Re: Project No. HL-12303-DLJ/RWW
FID No. 943190
Good Hope Hospital
Airborne Infection Isolation Room Renovation
Erwin (Harnett County)

The engineering portions of the construction documents dated March 24, 2021 (received April 16, 2021 – fee paid May 7, 2021) for the referenced project above have been reviewed for conformance with licensure rules for Hospitals (10A NCAC Chapter 13 Subchapter B). The drawings are not approved until we receive satisfactory written responses to architectural comments in DHSR letter dated June 2, 2021 and to the following engineering comments:

1 ELECTRICAL POWER - FLOOR PLAN
1/8"=1'-0"

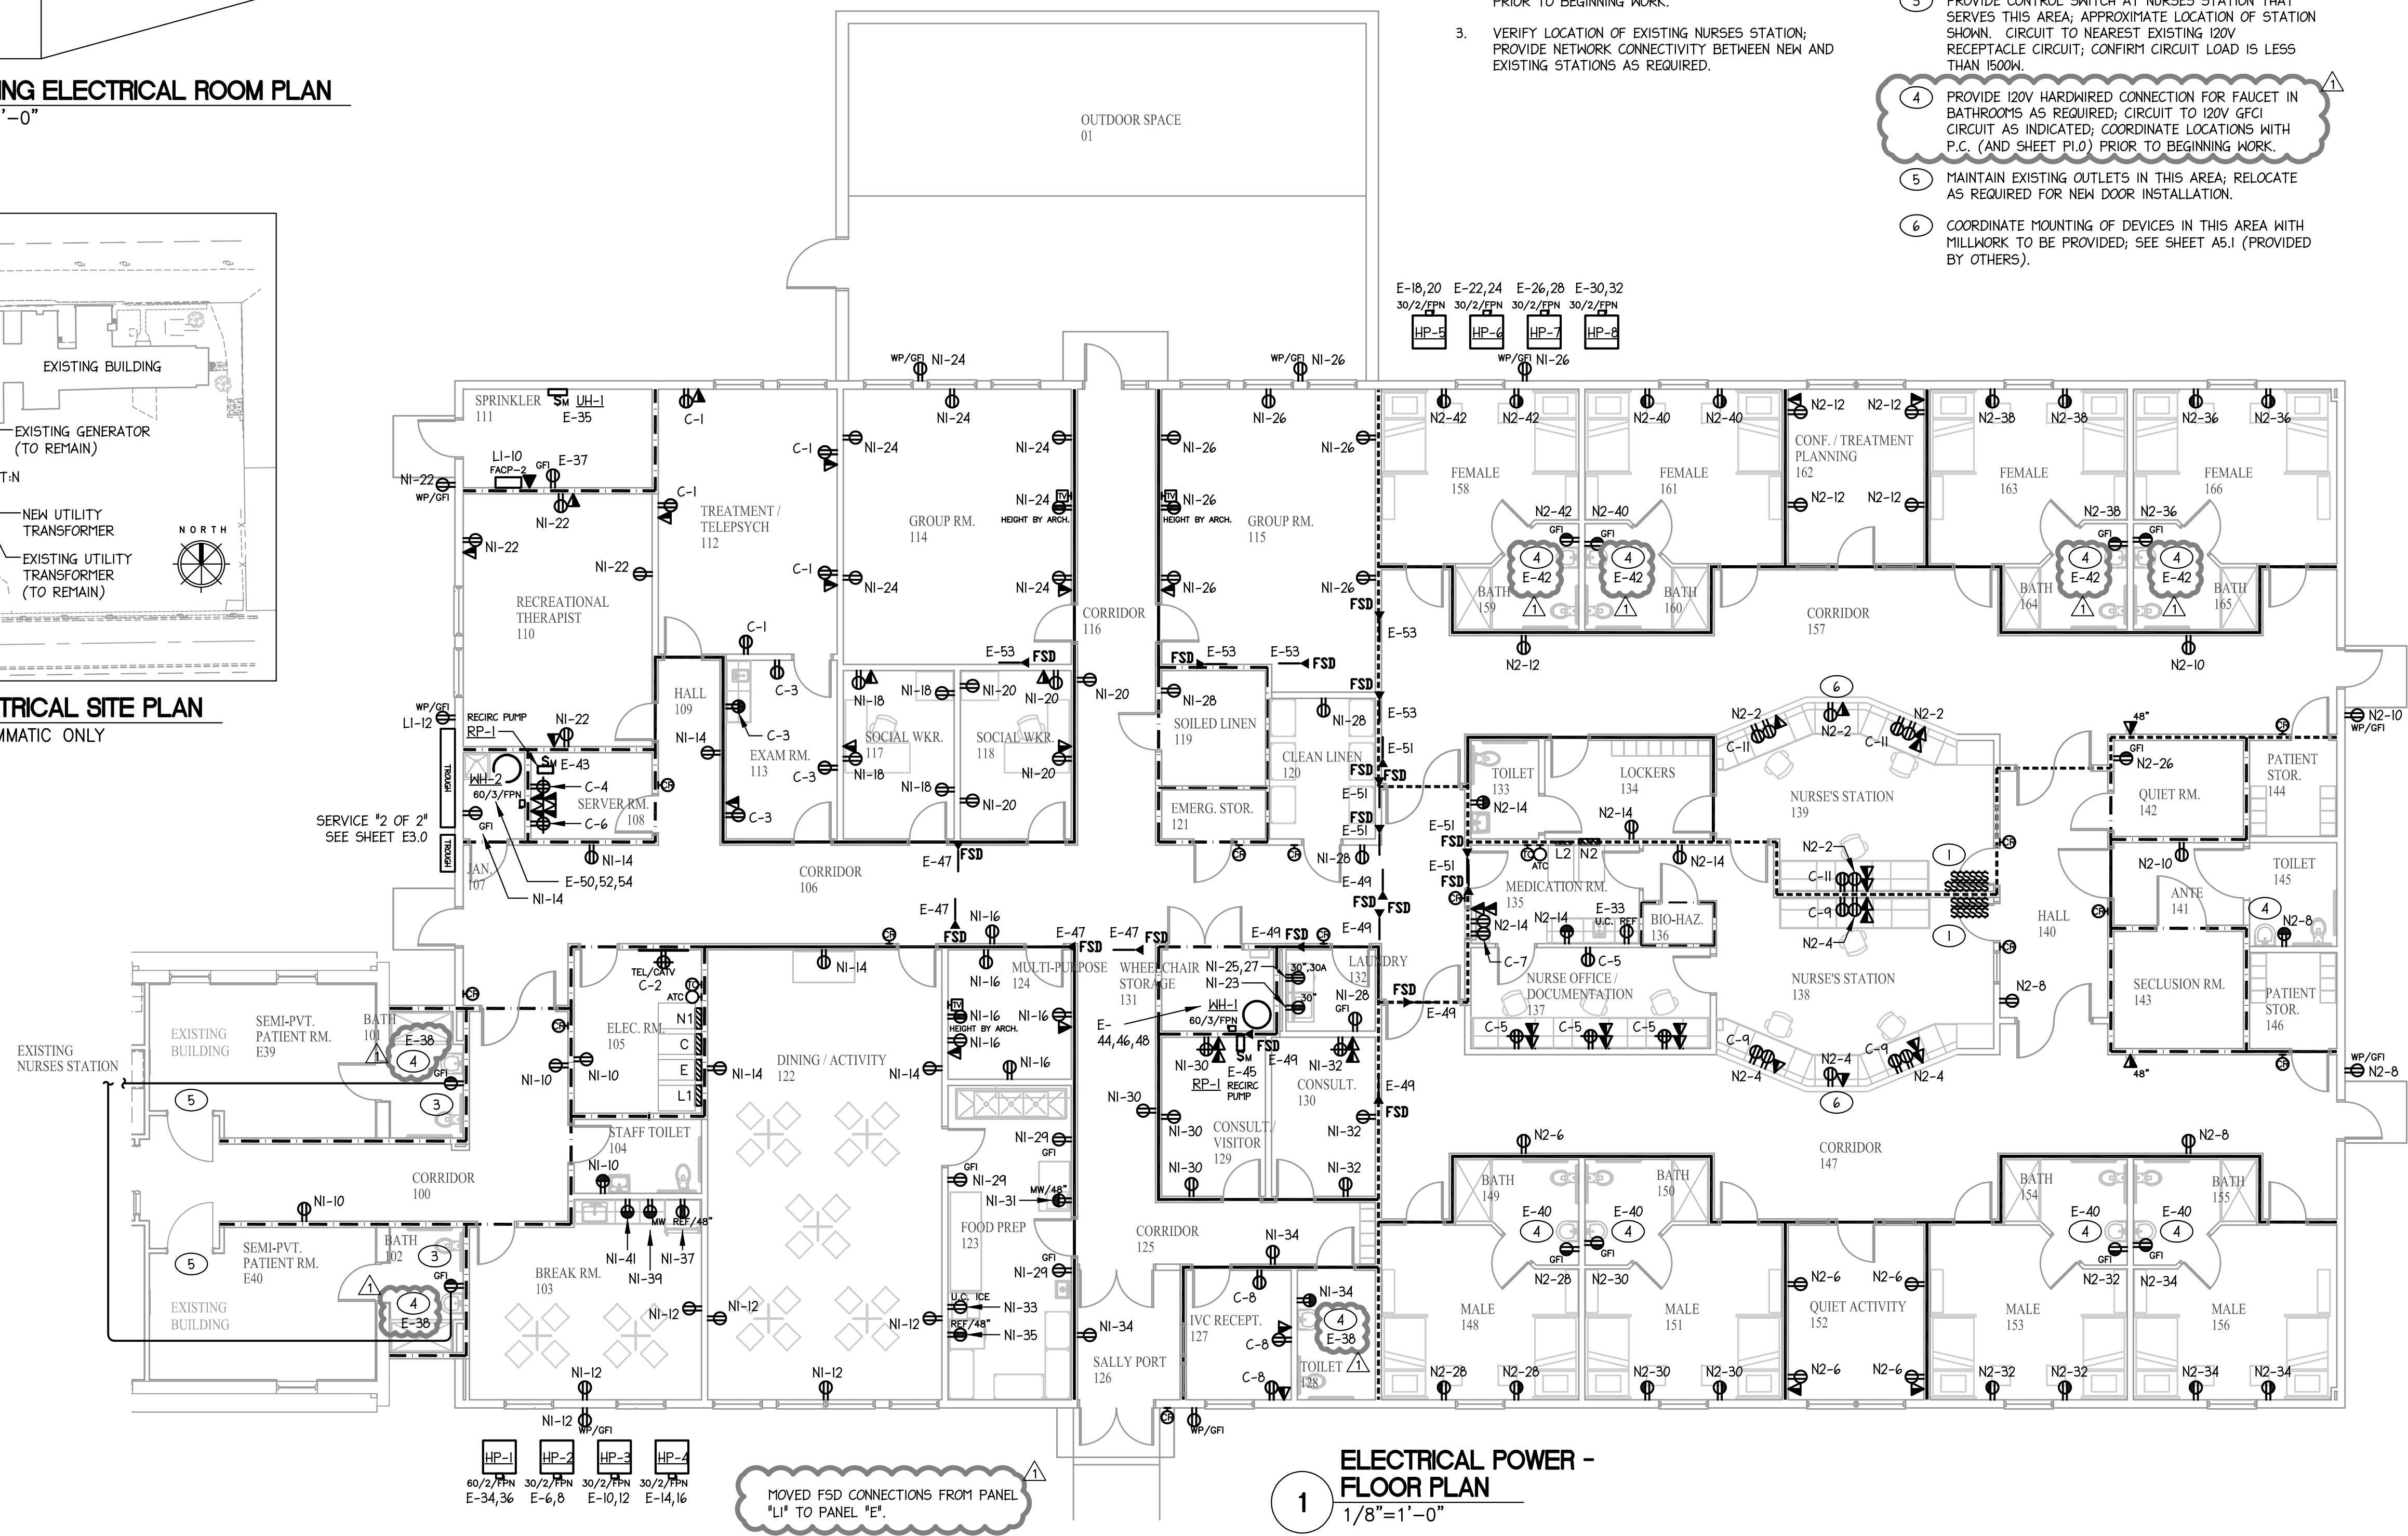
7. Reference Sheet E1.1: The quantity and location of electrical outlets indicated in these renovated rooms do not comply 2018 FGI, Table 2.1-2. Revise the drawings to indicate all new and/or existing outlets and to meet these requirements.

8. Reference Sheet E1.1: The drawings indicate two branch circuits in each room; Confirm that at least one circuit is from the critical branch of the essential electrical system and one from the normal system. [2017 NEC 517.18 (A)] This could not be determined from the drawings

9. Reference Sheet E1.1: Only general lighting is indicated in the AII rooms. Please address the following:
 - a. How will light for reading be provided to each patient bed? This is not indicated on the drawings. [2018 FGI 2.1-8.3.4.3 (1)(a)]

- b. How will night lighting be provided in each patient room? This is not indicated on the drawings. [2018 FGI 2.1-8.3.4.3 (1)(b)]
10. Reference Sheet E1.1: In the new AII rooms, anterooms, and bathrooms, please indicate which selected receptacles and task lighting are powered by the critical branch of the essential electrical system. This could not be determined from the drawings. [2017 NEC 517.34 (A) (8)]

11. Reference Sheet E1.1: No electrical outlet is indicated in the patient bathroom. Is there a need to provide a GFCI outlet in this space?
12. Reference Sheet E2.1: No nurse call devices are indicated in the AII rooms or patient bathrooms. Provide devices as required per 2018 FGI 2.1-8.5.1.2 and 2-18.5.1.3 and Table 2.1-2. Revise the drawings as necessary.
